## National Highways Planning Response (NHPR 21-09) Formal Recommendation to an Application for Planning Permission

### **Council's Reference: 21/03267/OUT**

**Location:** OS Parcel 0006, southeast of Baynards House Adjoining A43, Baynards Green

### **National Highways Ref: 92857**

BOUNDARY SECTIONS 11-15

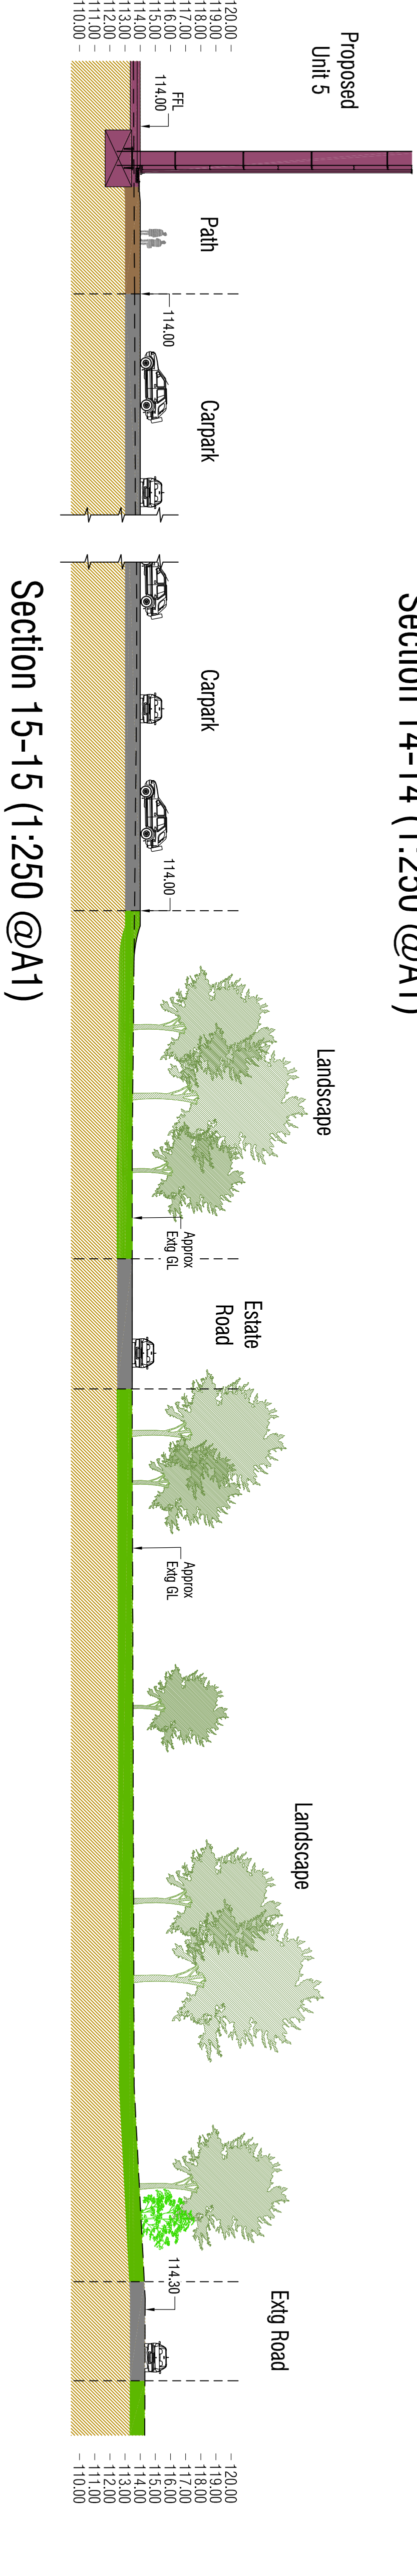
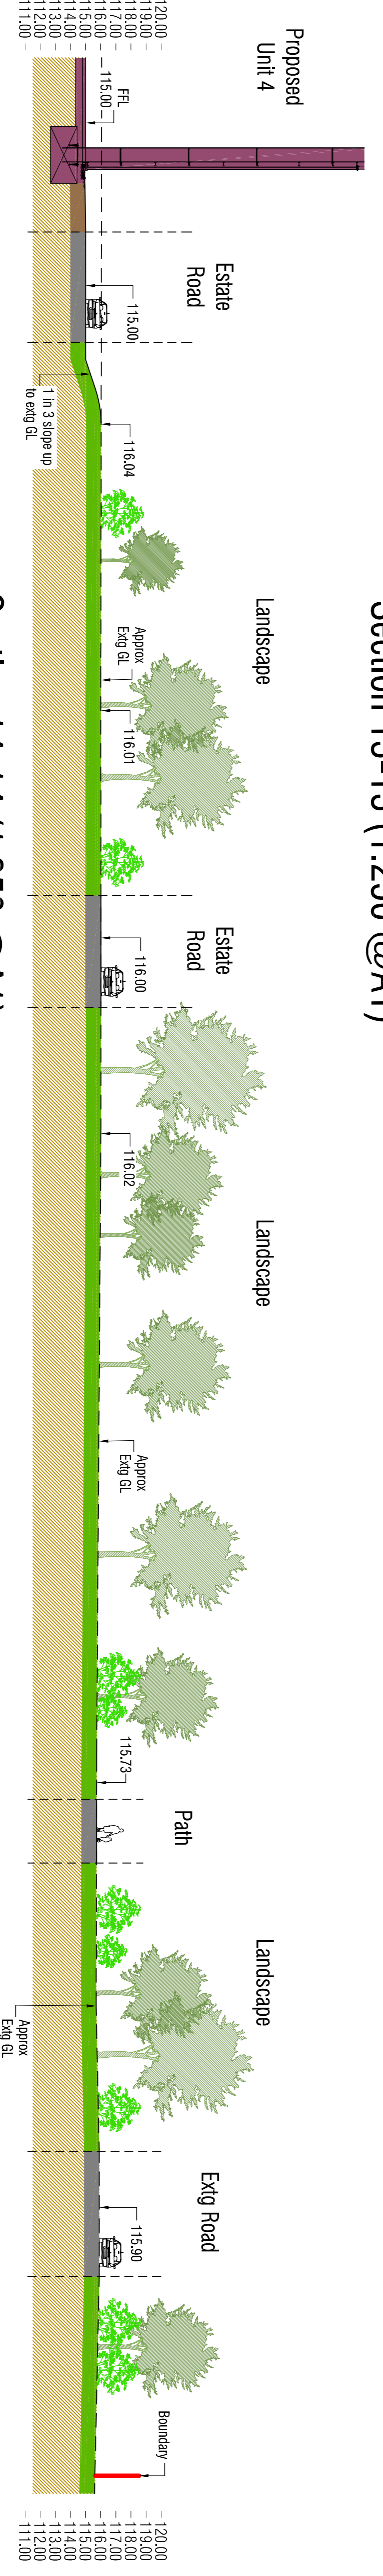
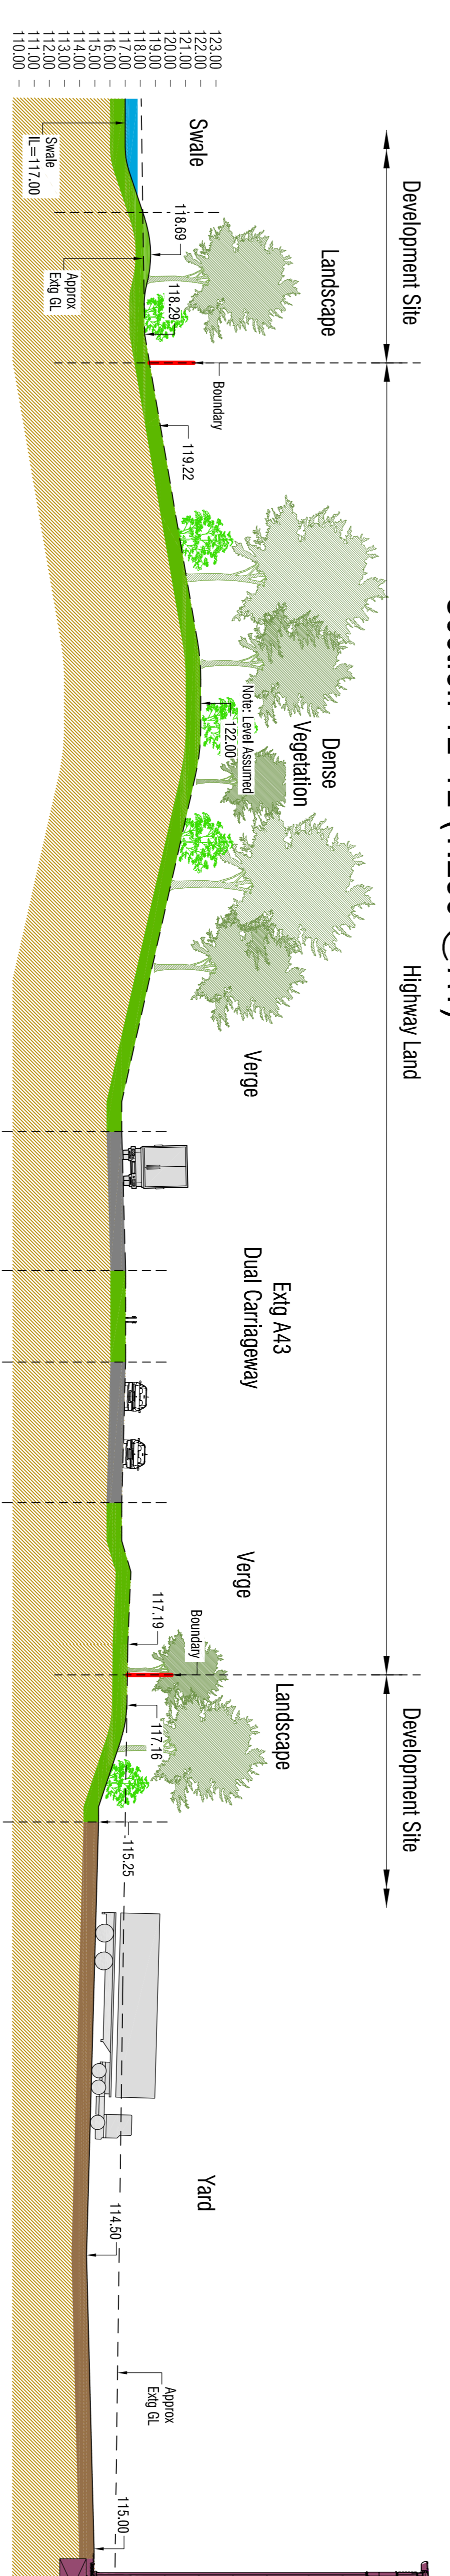
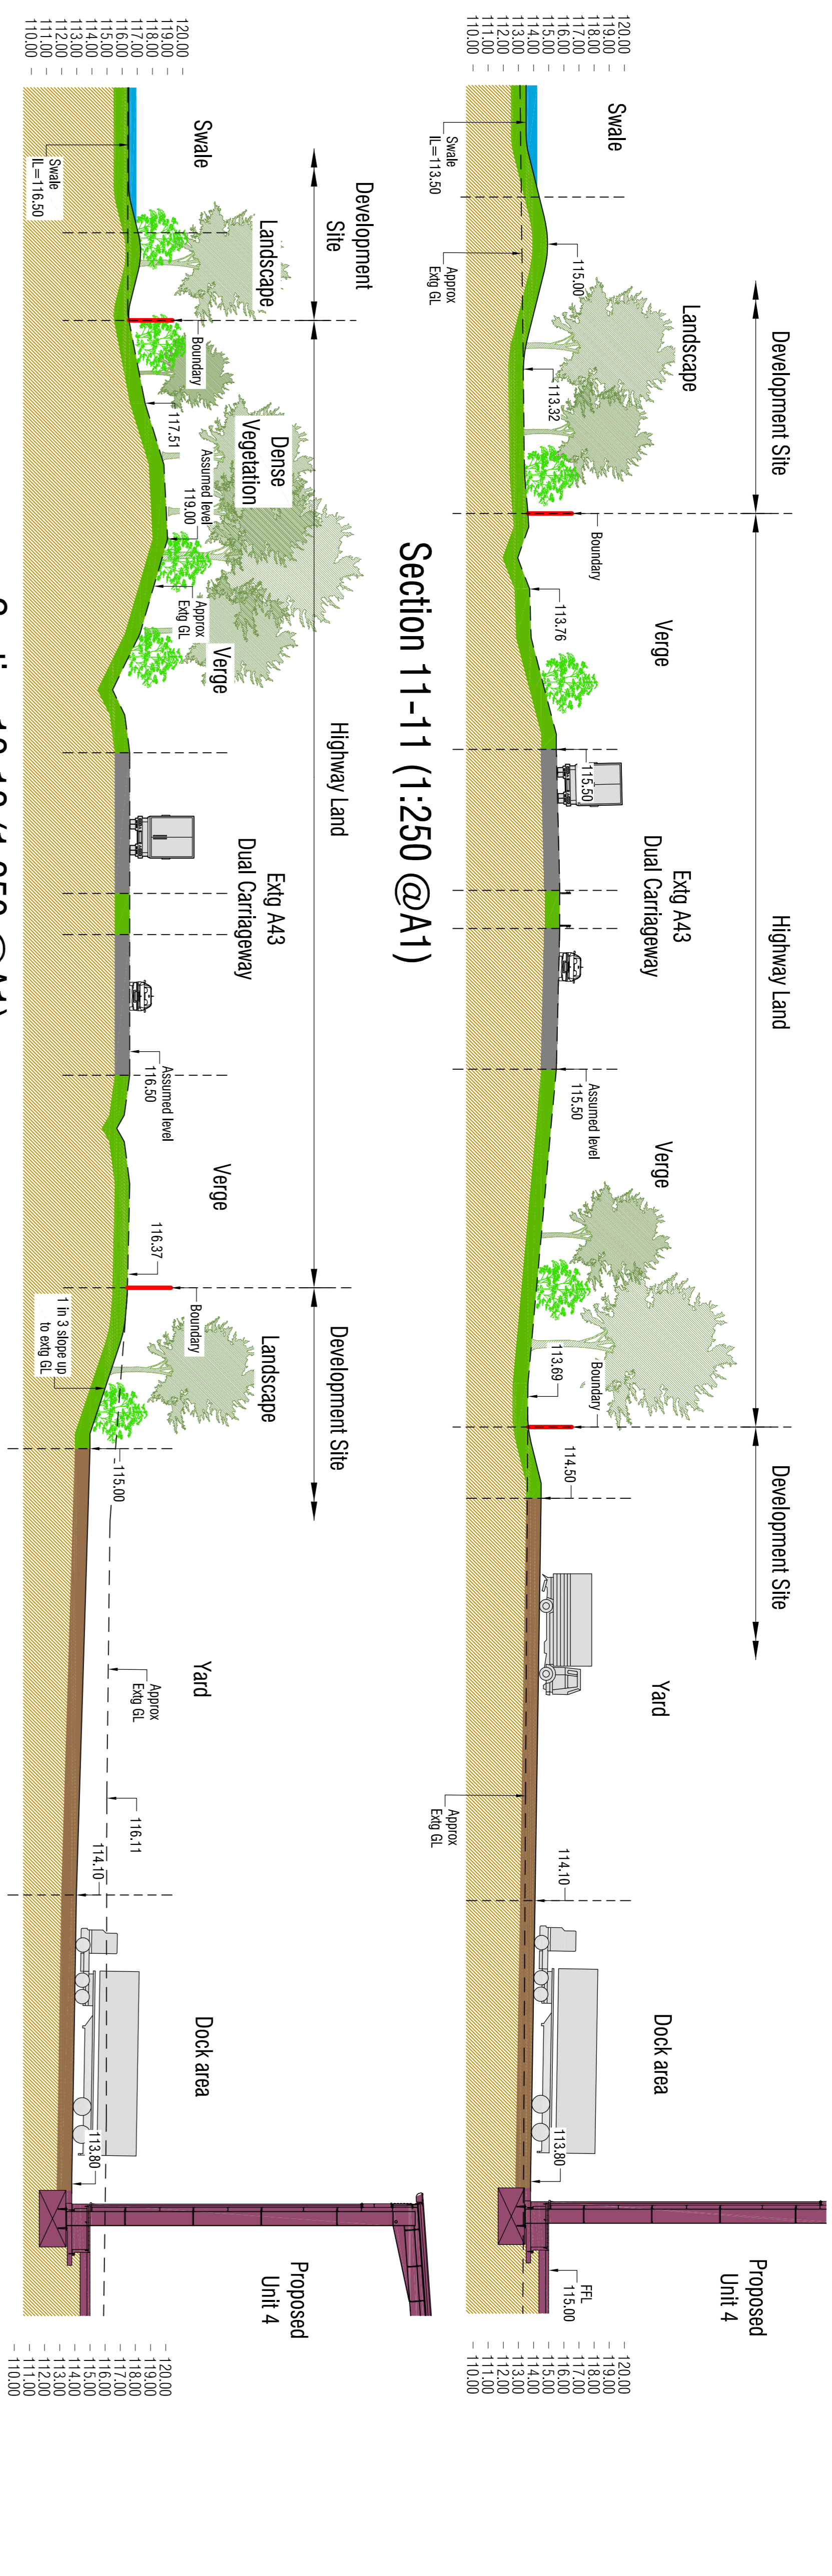
The applicant will need to advise / confirm if there will be any earthworks associated with the development(s) in relatively close proximity to National Highways boundaries (e.g. the stability of the balancing ponds, etc). In the first instance, some cross sections (to scale) through the boundaries showing the proposed extent of the development, its features and any proposed changes in elevation (excavations, landscaping) etc should be submitted for further assessment. Once received, we will review to determine the possible extent of any geotechnical reporting under the Design Manual for Roads and Bridges (DMRB) standard CD 622, which may be required to confirm the extent of any geotechnical risk to the SRN.

JOB TITLE		M40 JUNCTION 10		CLIENT		ALBION LAND	
DRAWING TITLE							
EASTERN ACCESS GENERAL ARRANGEMENT PRE-GROWTH FUND SCHEME							
SCALE	DRAWN BY	DATE	DRAWING No	REVISION			
1:500@A1	RM	03/08/21	17213-16-GA	P0

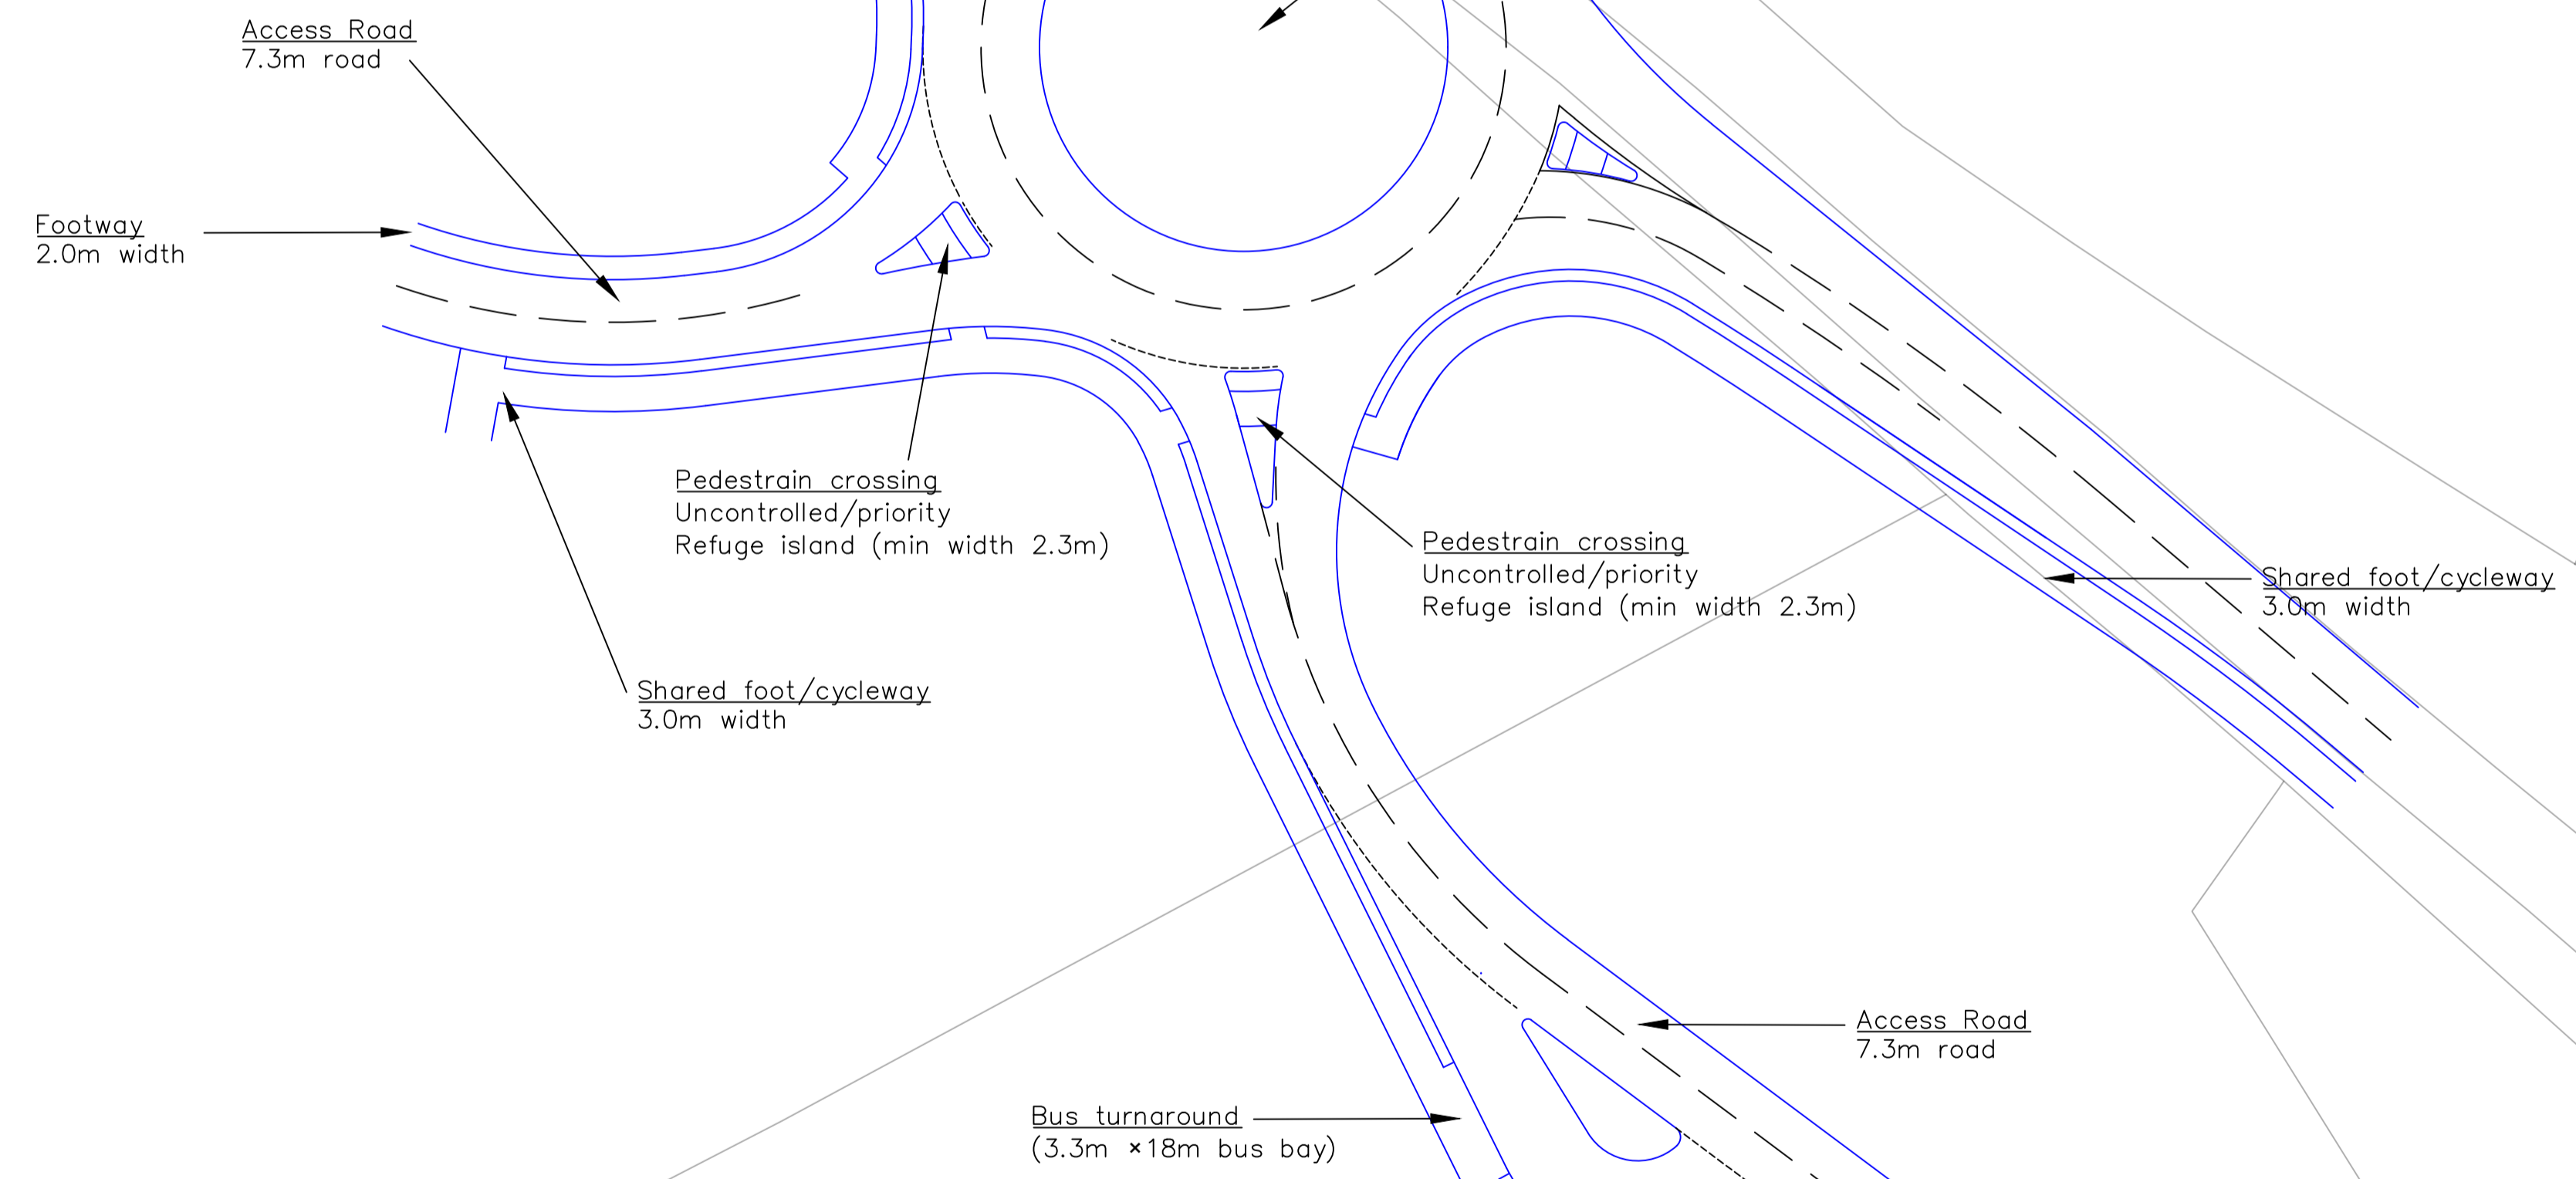
The applicant has proposed an interim mitigation scheme at the A43 Baynards Green roundabout which includes widening of the B4100 entries and a standalone signal-controlled toucan (pedestrian and cycle) crossing.

Given the concerns set out above and the uncertainty of some elements of the Growth Deal, there remain outstanding concerns. National Highways is therefore not yet in a position to comment on the suitability of the interim mitigation scheme.

Although, as noted above, we are currently not in a position to comment on the suitability of the proposed mitigation scheme, we have concerns about whether the scheme can be accommodated. The southeast quadrant is clearly outside of the current highway boundary, while the layout is right up to the edge of the boundary and appears to be outside of it on the south side of the B4100 west. In the case of the former, it is presumed that this is within land controlled by the applicant and will therefore be transferred to National Highways as part of the scheme; however, this should be confirmed.

The latter zone is more concerning as in this area there will be a need for additional infrastructure at the back of the proposed footway / cycleway, such as lighting columns, drainage and signposts. Embankments or retention structures will also be

required if there is any level difference. Our initial assumption is that the land to the south of the B4100 west arm is owned by a third party and therefore cannot be required for conditioned mitigation, unless the applicant can clearly demonstrate they have already secured the necessary rights to use this land and will transfer it to the relevant highway authority as part of the works.
